Current Zoning: N1-A (Neighborhood 1-A)  
Proposed Zoning: CG (CD) (General Commercial, Conditional)

Approximately 0.97 acres located on the south side of West Mallard Creek Church Road, east of Claude Freeman Drive, and west of Stelfox Street.

The petition proposes to develop a small scale shopping center with up to 8,650 square-feet of commercial/retail space as allowed in the General Commercial Zoning District.

**SITE PLAN-1**

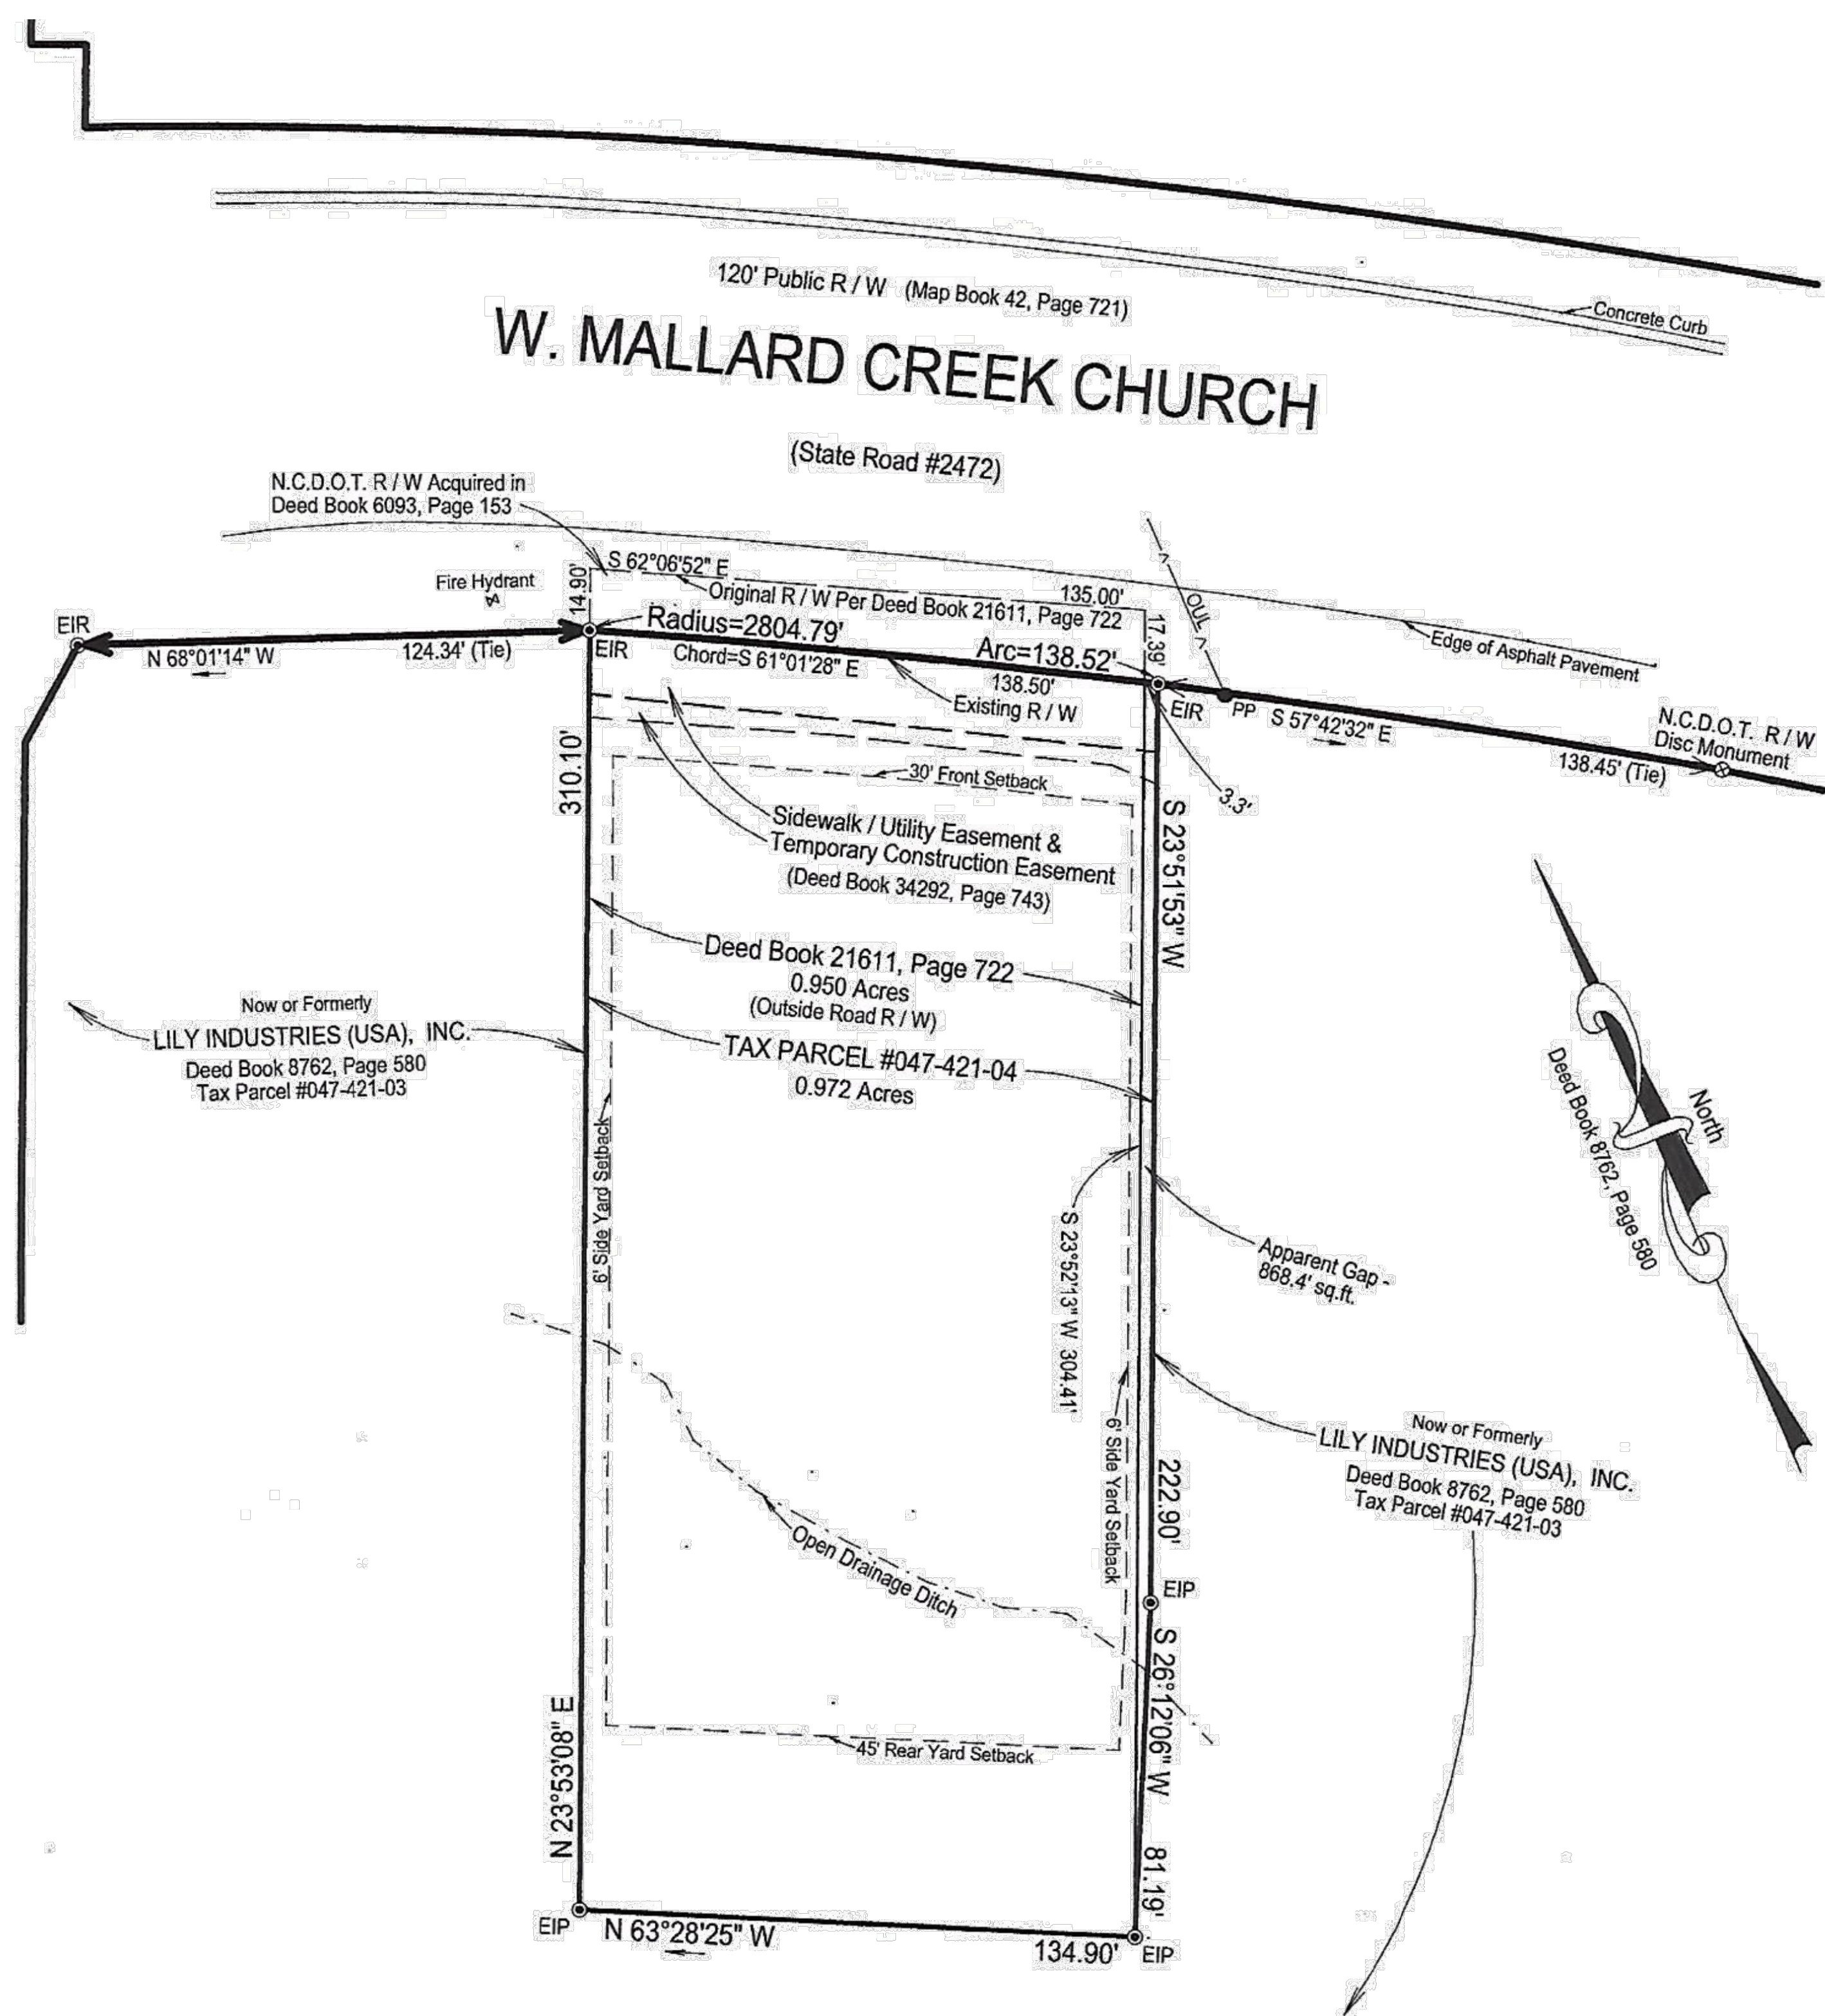
1. ~~There is a 10-foot no-build zone around tree-save area.~~ **Addressed**
2. ~~Can not have sight triangles within tree-save area.~~ **Addressed**
3. ~~Provide a tree survey.~~ **Addressed**
4. ~~Must provide a minimum of 15% tree save.~~ **Addressed**

5. ~~Remove note 12 and state lighting will meet section 16.2 requirements.~~ **Addressed**
